**From:** Tim Screen  
**Sent:** 11 May 2022 12:52  
**To:** Andrew Lewis  
**Subject:** 21/04289/OUT - OS Parcel 1570 Adjoining And West Of Chilgrove Drive And Adjoining And North Of, Camp Road, Heyford Park

### LVIA

### Illustrated masterplan

APPENDIX 3 ILLUSTRATIVE MASTER PLAN DRAWING PO6 REV B

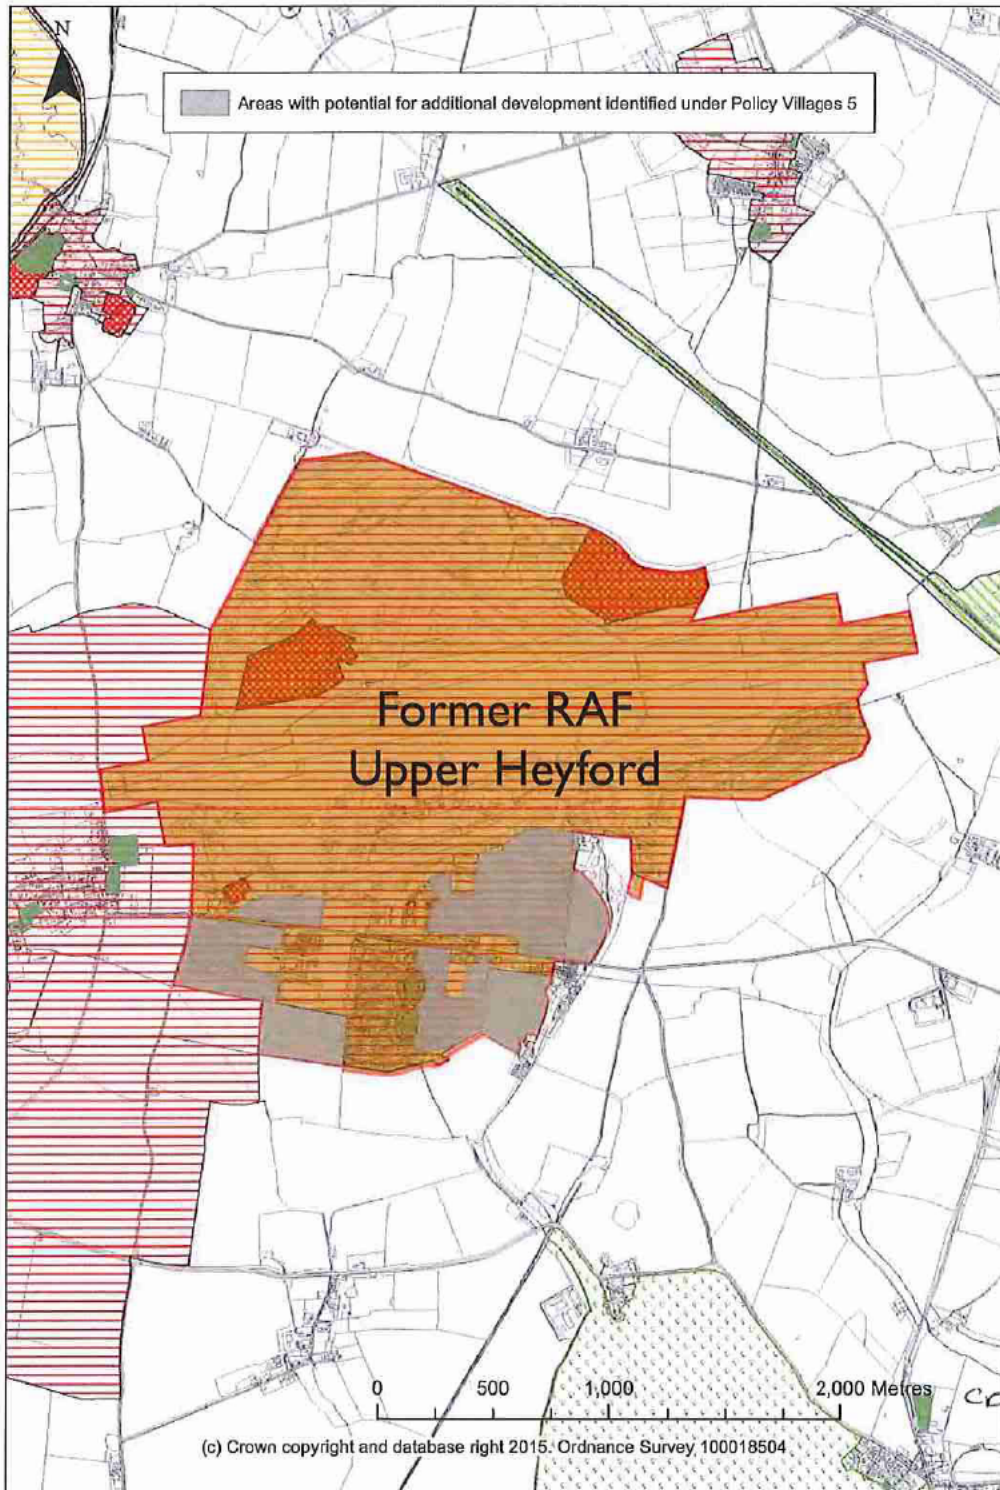
The proposed native tree belts however they will restrict resident's enjoyment of east-facing gardens because overshadowing trees resulting in light level reduction (residents may complain and wish to fell trees because of this issue). The tree belt appears to be against the rear garden boundaries where restricted surveillance and limited public and maintenance access may encourage resident to illegally extend their gardens (it does happen). I therefore recommend that a publicly accessible 6-8 m wide minimum landscape buffer with path is designed into the layout.

Very encouraging to see street trees. For the streets and open space the 'right tree in the right place' is crucial for urban GI and its success. In this regard the landscape consultant should consider <https://www.tdag.org.uk/tree-species-selection-for-green-infrastructure.html> (Trees Design Action Group's tree species selection).

The county should confirm that they are able to adopt these trees.

With a trigger of 10 dwelling this requires a LAP, 50 dwelling requires a LEAP and 100 dwellings a NEAP. The LAP should be located in the central space within the eastern development parcel and a Combined NEAP/LEAP located in the space south for the built form in the western development parcel.
